**CITY OF ALBUQUERQUE
PLANNING DEPARTMENT
August 14, 2013
DRB Comments**

PROJECT # 1009447 APPLICATION # 13-70648

RE: Lots 1-4 & Tract A, Mesa Verde Addition

RE: DRB Project No: 1009447 Preliminary Final Plat Request
Lots 2-A and 4-A, Block 19, Mesa Verde Addition
Zone Atlas Page K-19-Z

1" = 10'  
 PROJECT NO. MESA VERDE  
 DRAWN BY: RUL  
 ZONE ATLAS: K-19

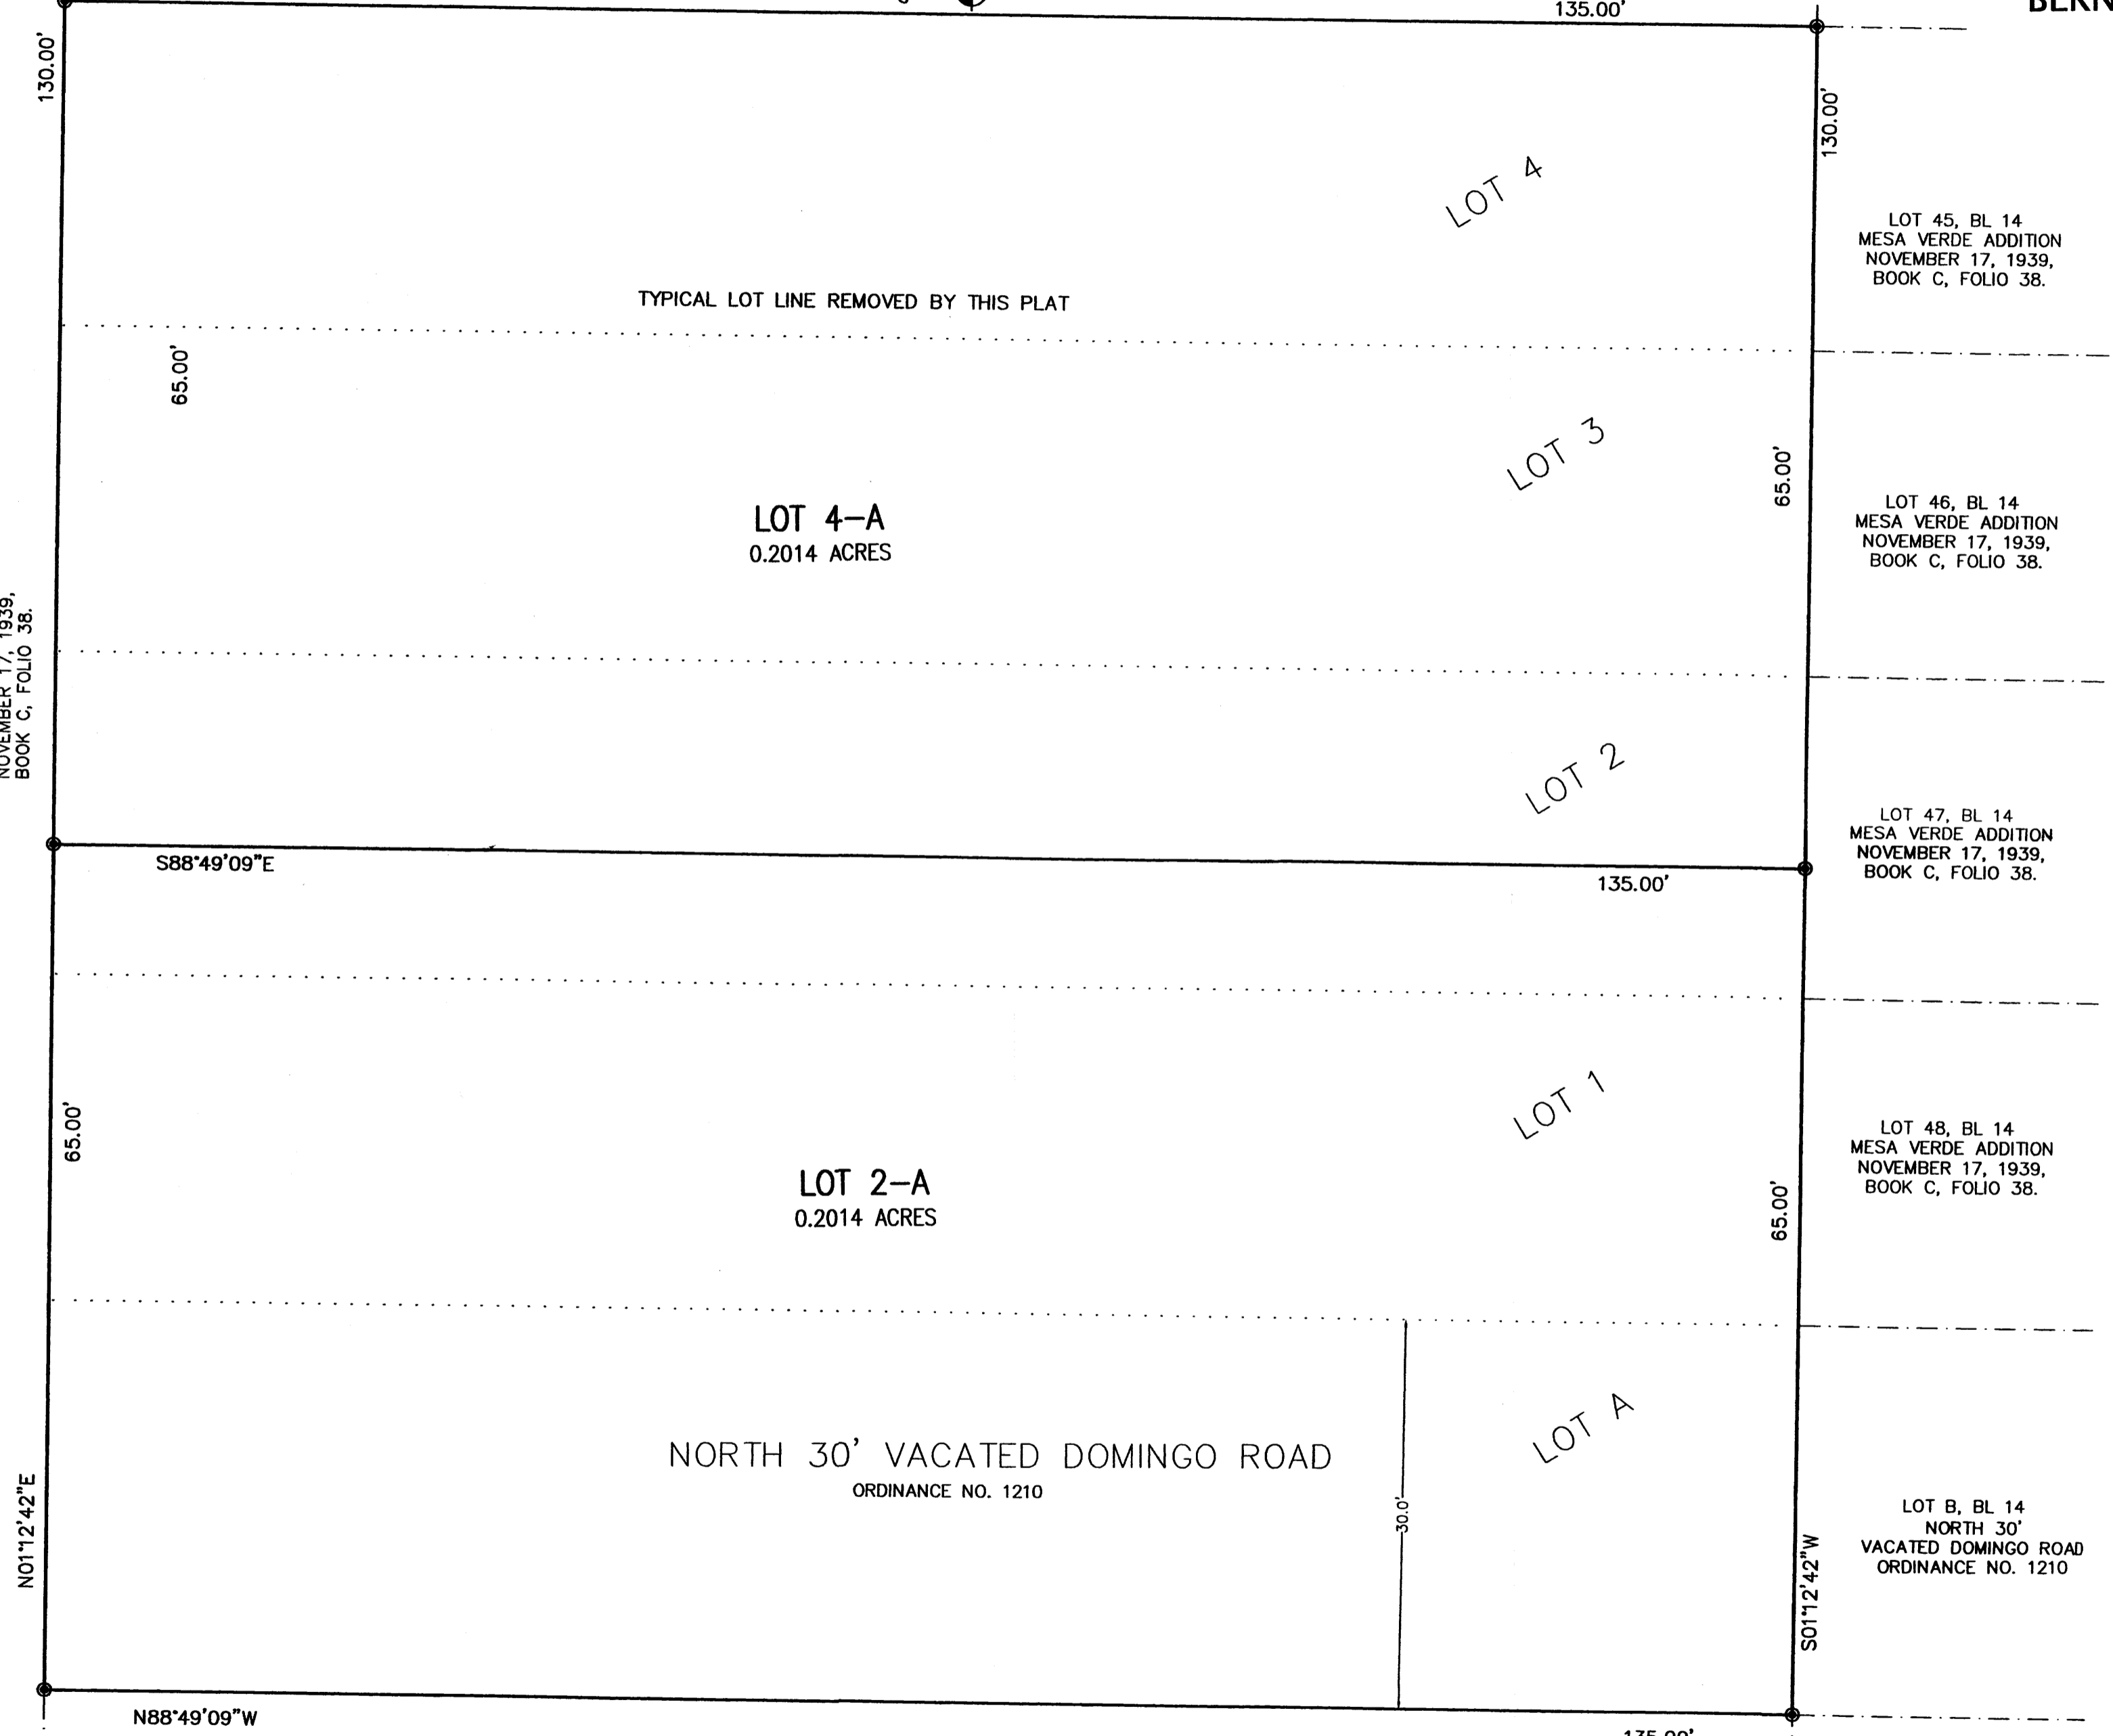
Please renumber Solar Note as No. 11; based on the APS Agreement Waiver, please remove APS Agreement note from final plat.

Remove zoning note (No. 9) for final plat.
